WEST SUSSEX COUNTY COUNCIL CONSULTATION

TO:	Arun District Council FAO: Mr S Davis
FROM:	WSCC - Highways Authority
DATE:	6 July 2021
LOCATION:	Lidsey Lodge Farm Sack Lane Lidsey PO22 9PE
SUBJECT:	AL/75/21/PL Demolition of large agricultural buildings, removal of concrete yards and access, erection of 4 No.2 bed houses, 2 No. 3 bed houses, 2.No. 4 bed houses, gardens, access, parking, soft landscape and ecology areas. (resubmission following AL/27/21/PL). This application is a Departure from the Development Plan and is in CIL Zone 3 and is CIL Liable as new dwellings.
DATE OF SITE VISIT:	n/a
RECOMMENDATION:	No Objection
S106 CONTRIBUTION TOTAL:	n/a

BLOCK / SITE LAYOUT PLAN
SCALE 1:500 AT A3
0 10 20 30M

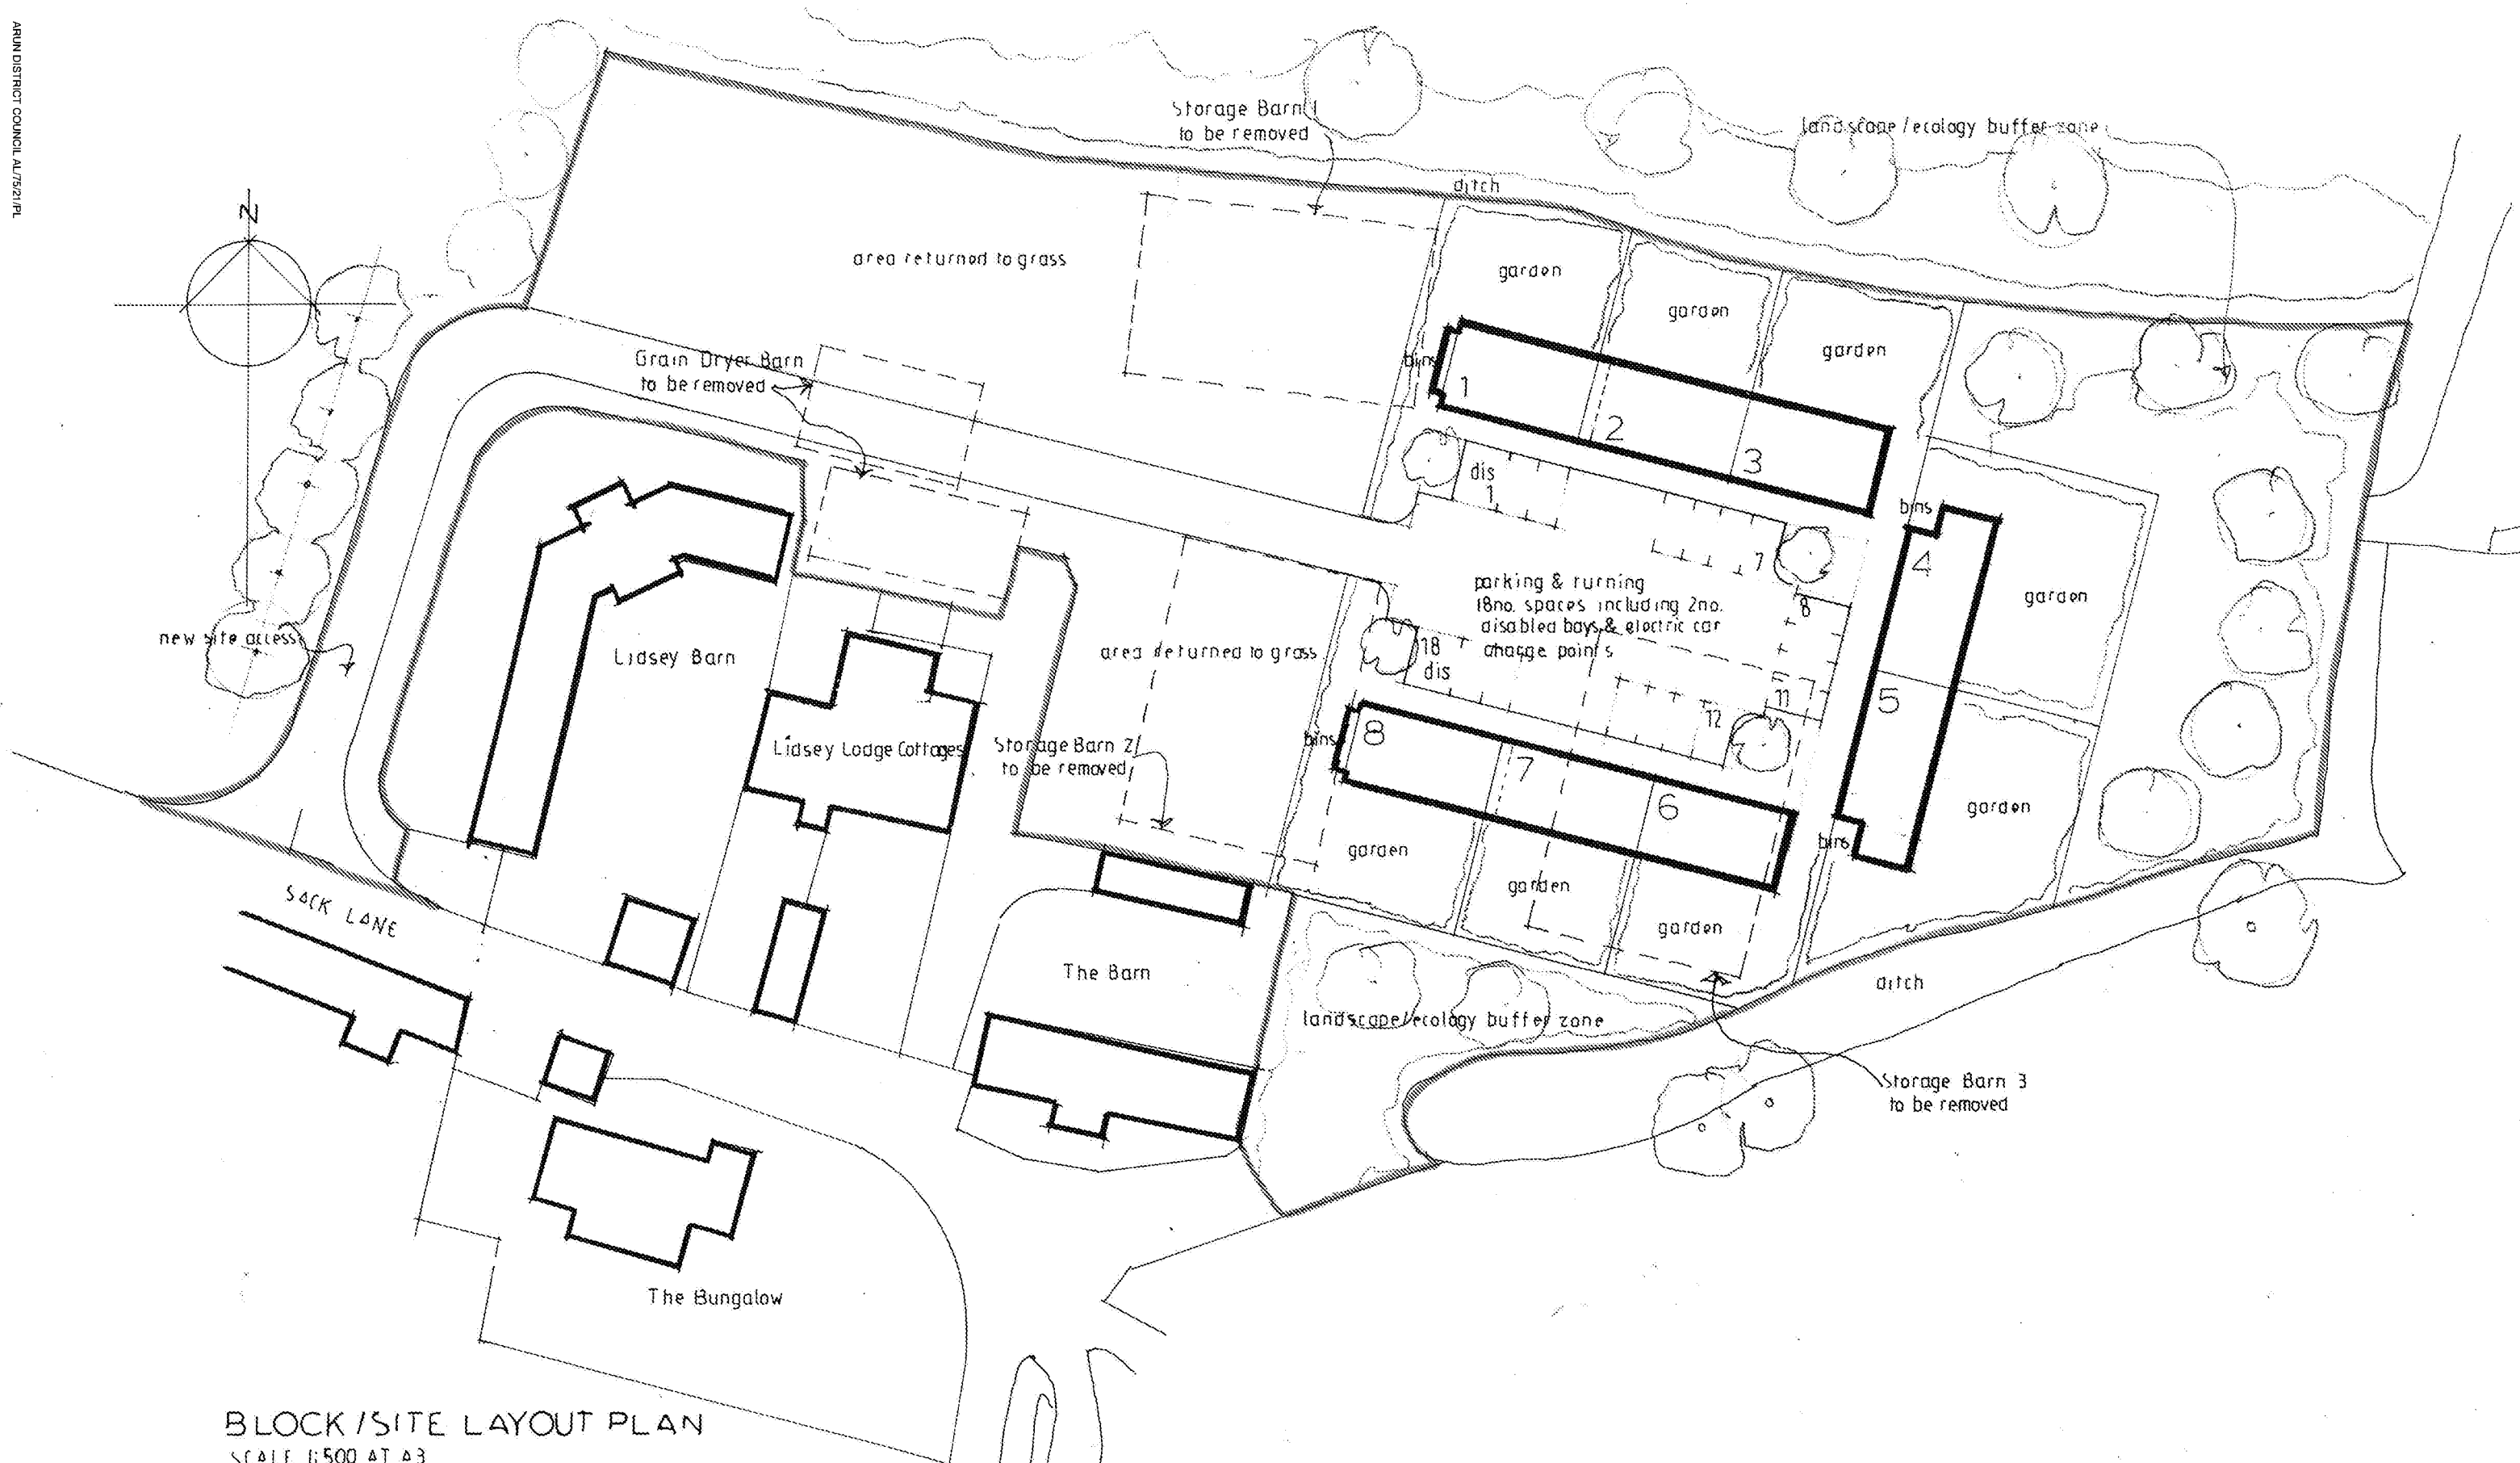
The Block/Site Layout plan shows a new access onto Sack Lane very close to the alignment of the existing access. It appears to be private property, however can the applicant confirm this in relation to the Highway Boundary to determine if a Minor Works Licence is required. If it is to join public highway, further details of the access design will be required.

- Confirmation of access design/proximity to public highway
- Confirmation cycle parking will be secure
